**ADC Planning Consultation
Response from the Conservation Officer**

Application Number	AW/62/15/HH
Address	53 Kingsway Aldwick PO21 4DN
Description	Conservatory & double entrance doors. Amendment to previous permission AW/201/14/HH.
Case Officer	Mrs. J Chapman

Title
EXISTING &
PROPOSED
ELEVATIONS
Project
SPEEDWELL
KINGSWAY
CRAIGWELL EST.

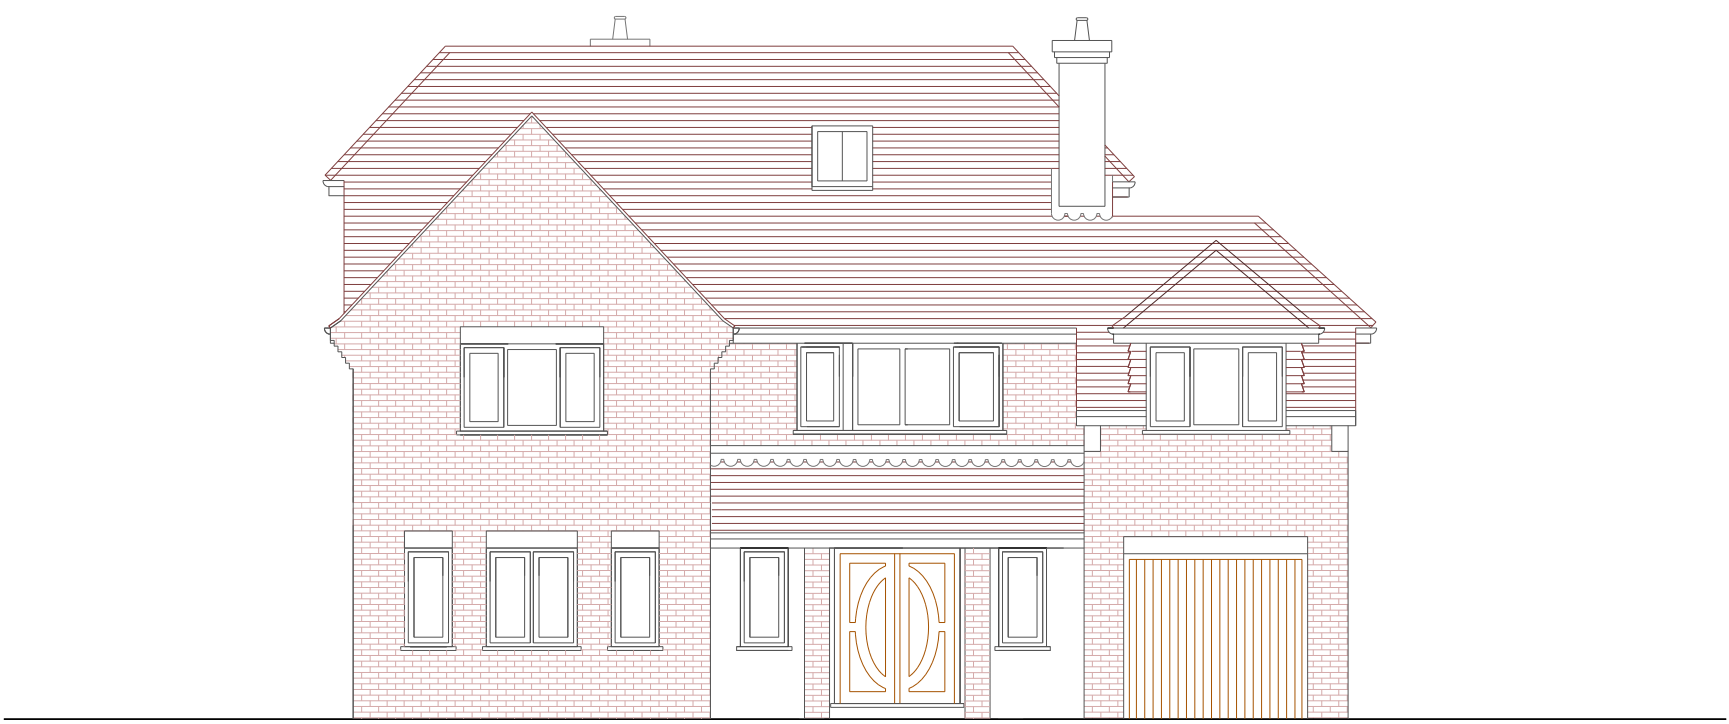
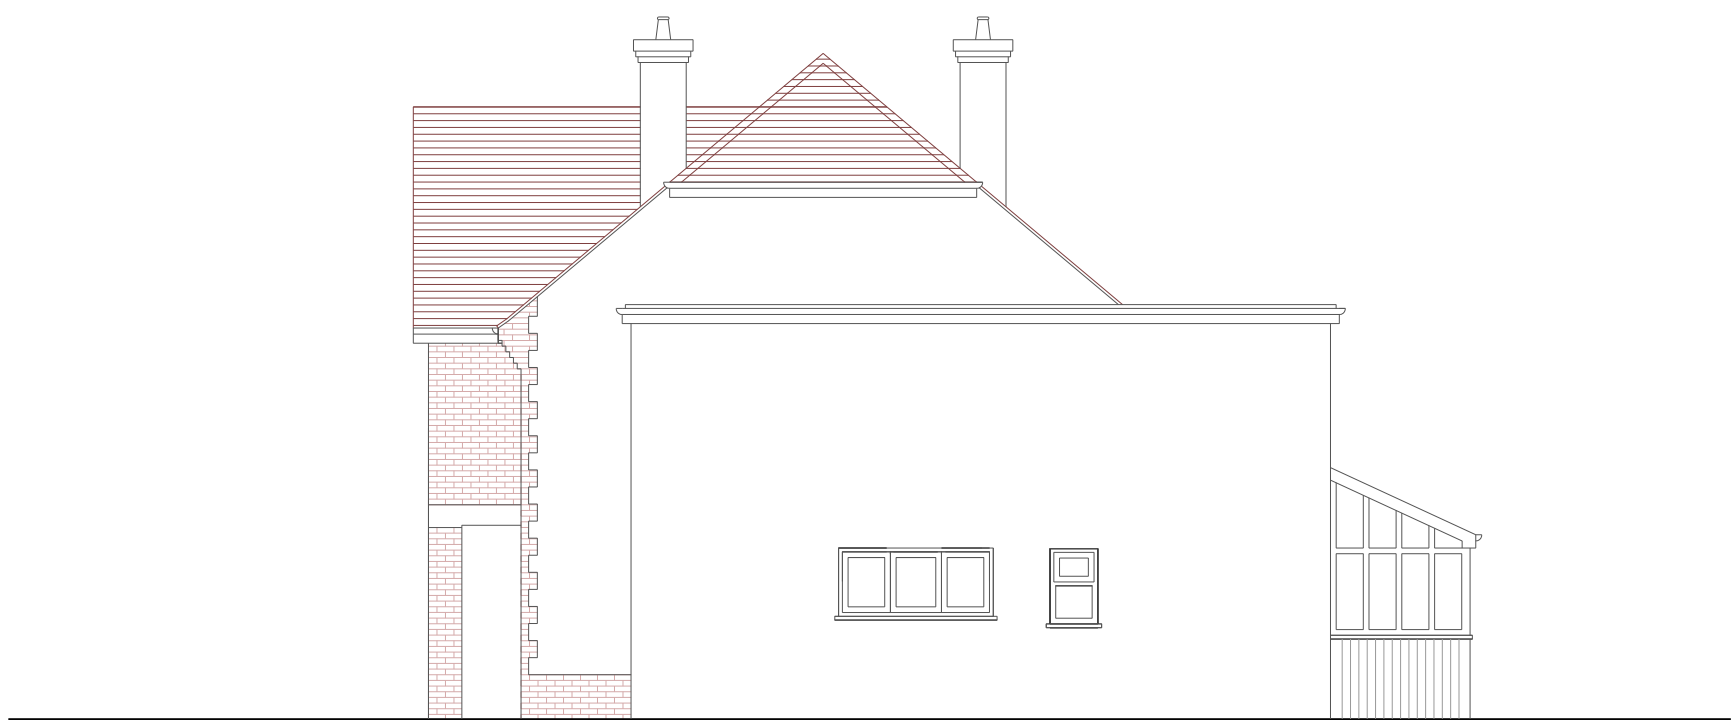
The revisions to the front of the property are minor, but their success will depend upon the quality of the materials used and the details of the windows and doors. Please condition details of the windows and doors.
